To: All Staff
From: Environmental Health
Date: April 29, 2025
Subject: AU-25-00008

SITE PLAN

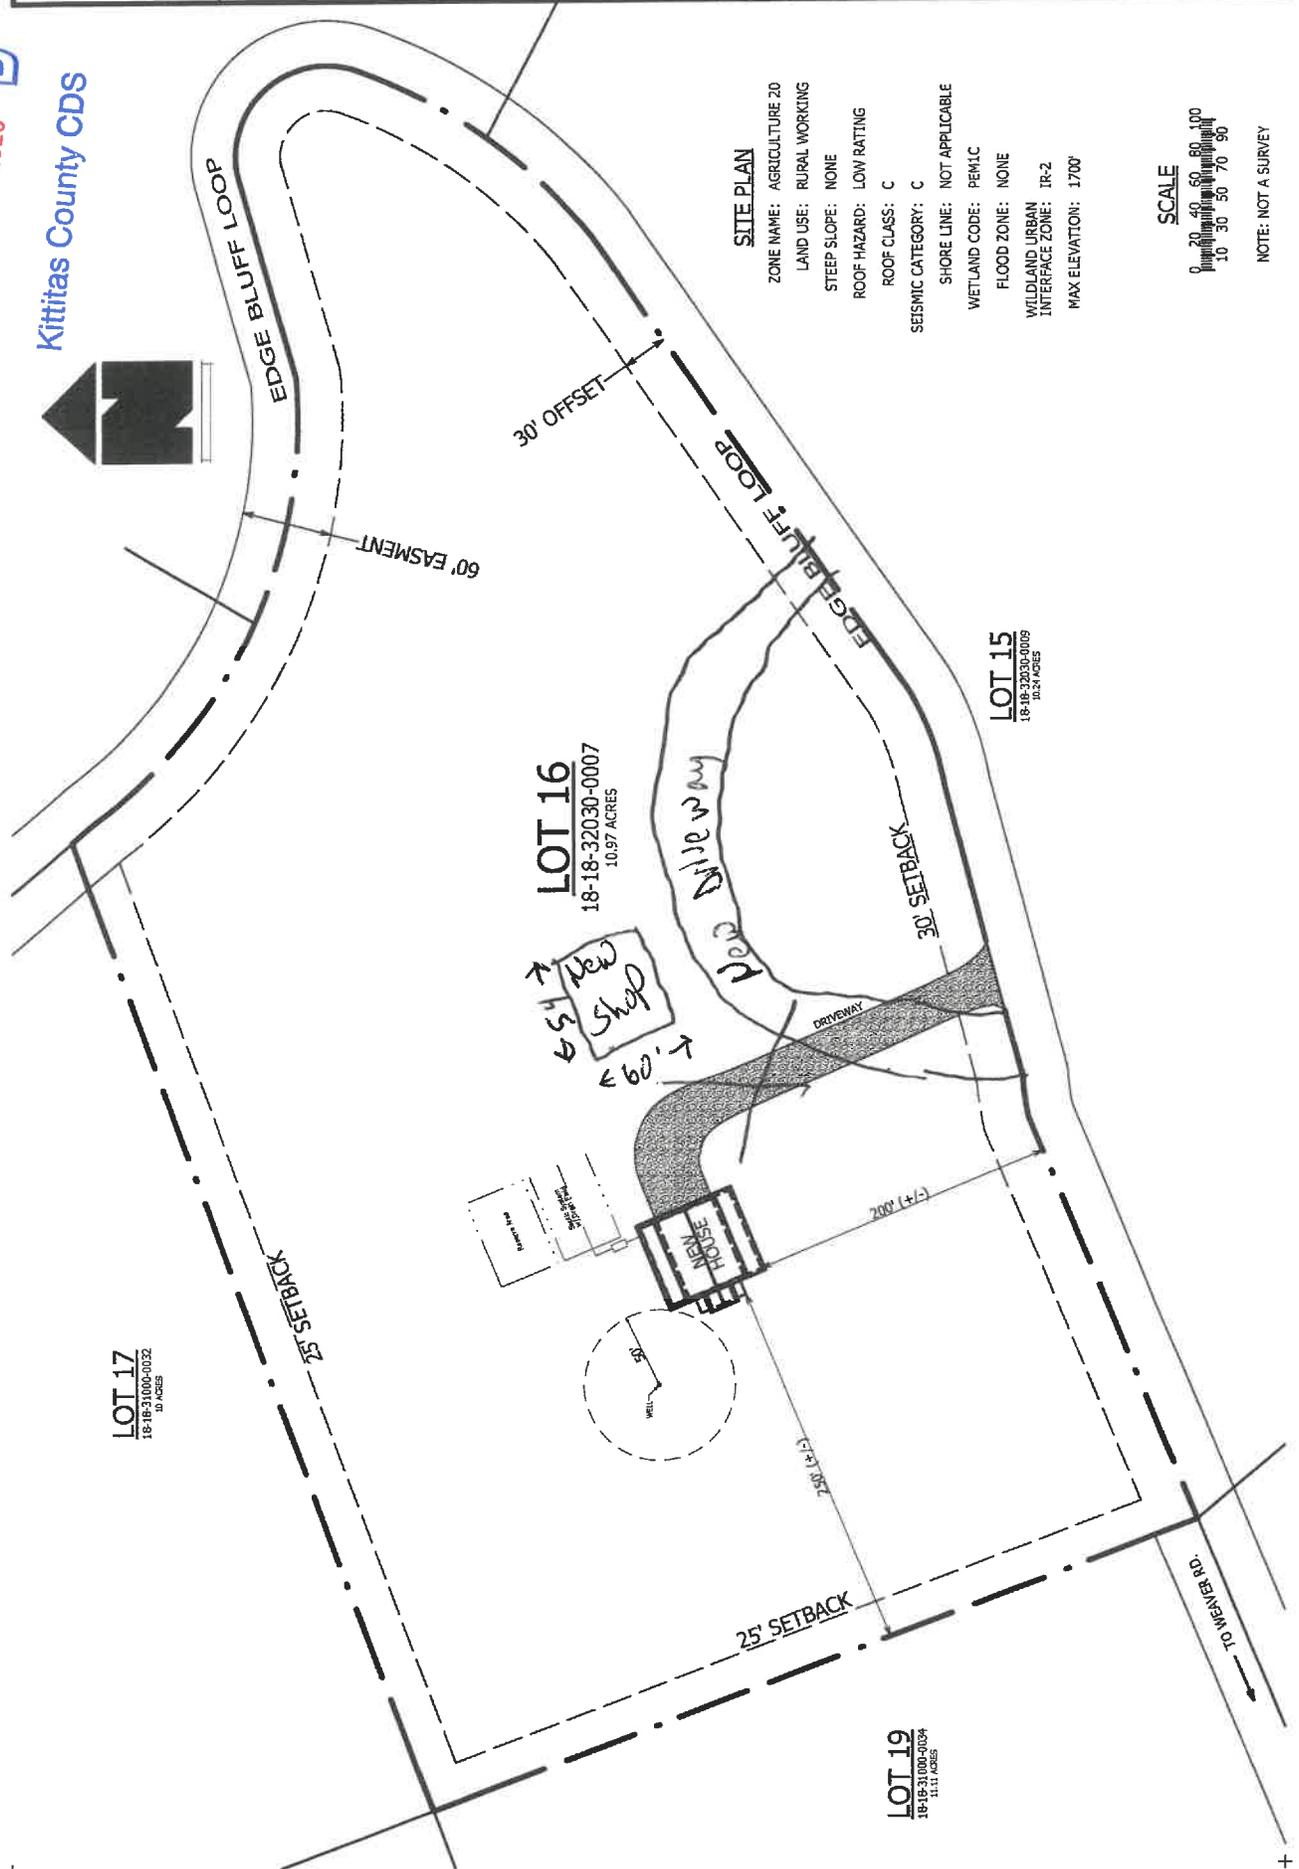
Drinking Water	<ul style="list-style-type: none">• An adequate water supply determination form I/S with shared well user agreement is required for connection to the well.
Wastewater	<ul style="list-style-type: none">• An installation permit is required for connection to the existing OSS.
